# Albuquerque Bernalillo County Water Utility Authority

## Development Facilitation Team (DFT) – Review Comments

**Project No: PR-2022-007986 Date: 4/2/2025      Agenda Item: #8      Zone Atlas Page: F-10**

**Request: Subdivide the existing lot into 6 lots served by a new extension of Cleghorn Rd**

64th Subdivision
Sketch Plat
4421 64th Street NW

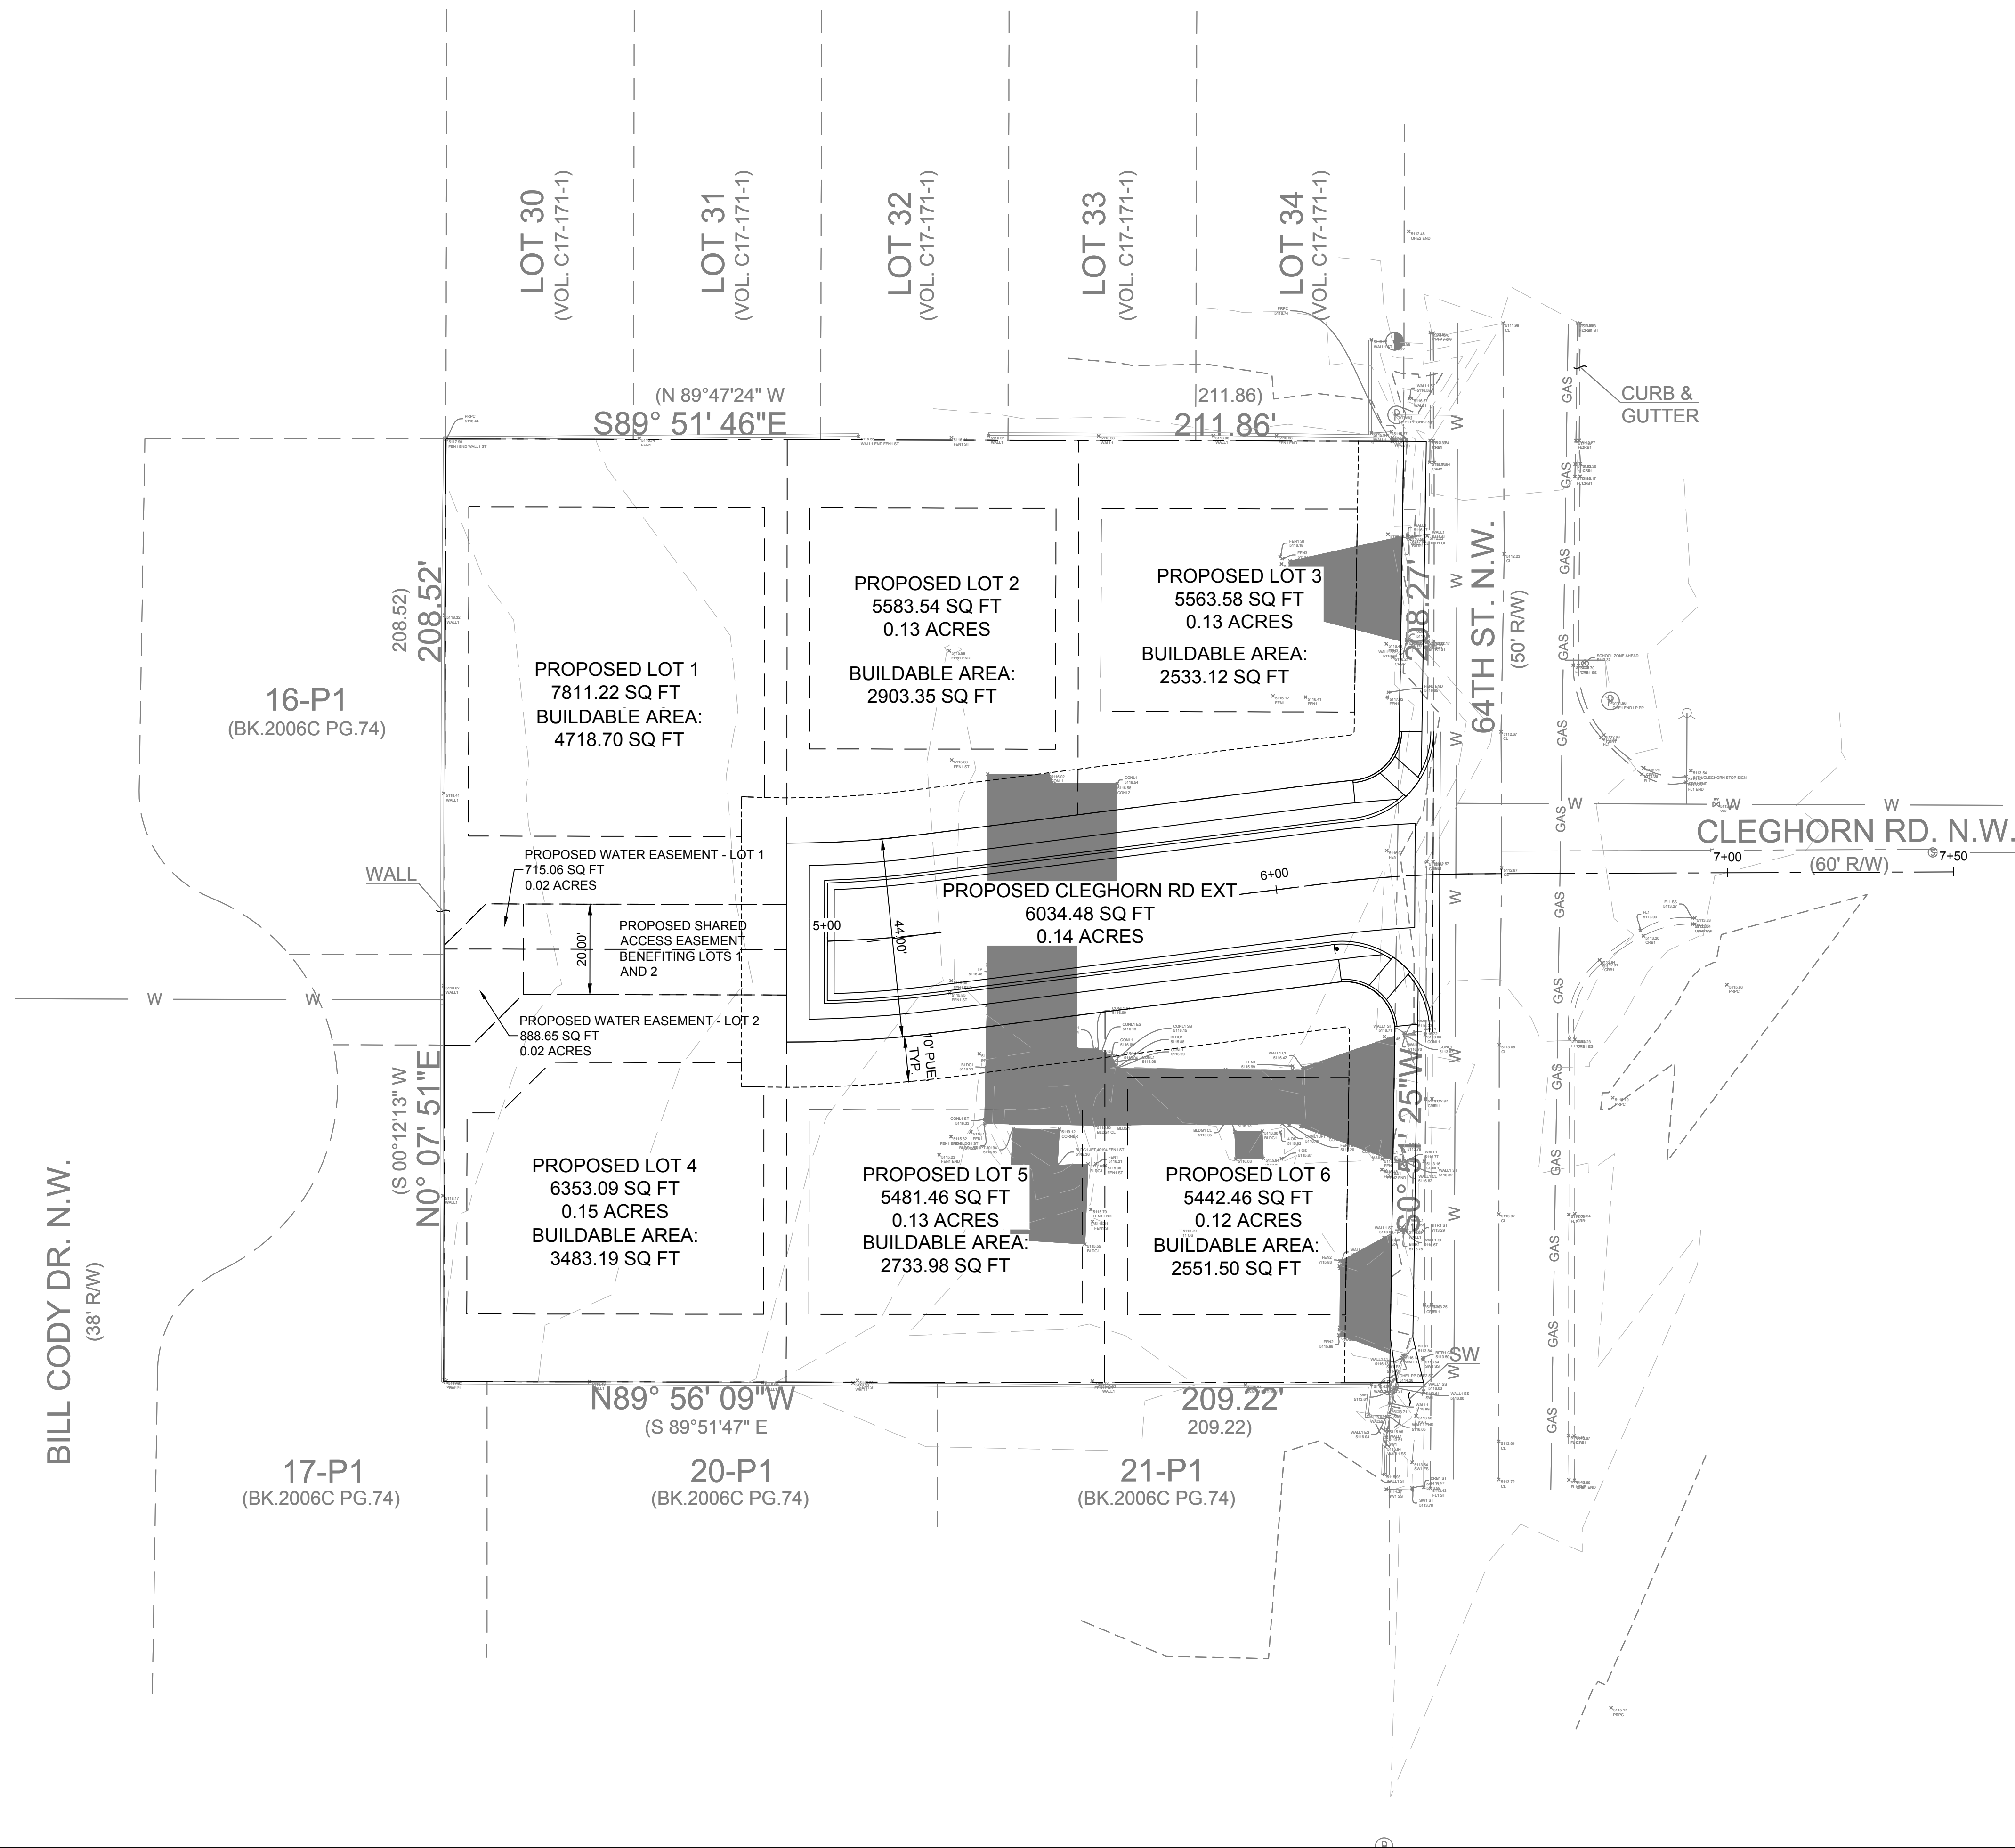
1. 64<sup>th</sup> is a local street and requires 5' sidewalks with a 4' to 6' landscape buffer. Your cross section shows proper proposed sidewalk but only 2.4' of buffer. Transportation defers to Planning and Parks to determine if this will be sufficient.
2. The proposed extension of Cleghorn will also be a local and will require the same 5' sidewalk with 4' to 6' landscape buffer. Please provide dimension on the plan or in a cross section to show proposed sidewalks and buffer will be adequate.
3. The proposed access easement is shown at 20' wide, but for access to 2 properties it is required to be a minimum of 22' wide.

- This is a request for a Sketch Plat review to subdivide an unplattoned lot in the Town of Abq Grant into six separate lots, each approximately 0.13 acres in size. The re-plat includes a proposed 20-foot-wide public water easement and a proposed 10-foot wide Public Utility Easement (PUE) around the proposed right-of-way (ROW).

- Demonstrate compliance with Section 7 of the DPM, Table 7.2.29, regarding Sidewalk width requirements and its landscape buffer.  
64<sup>th</sup> St is a local street and requires 5' sidewalks with 4' to 6' landscape buffers.

- Applicant proposes a new private access and utility easement on the east side of the subject property. Per **5-3(E)(1)(f) Private Ways** Private ways to provide access to subdivision lots shall be created only where public right-of-way would not better serve public purposes and where private ways can adequately serve all identified transportation, utility, and stormwater handling requirements. Private ways shall be subject to all of the following requirements.
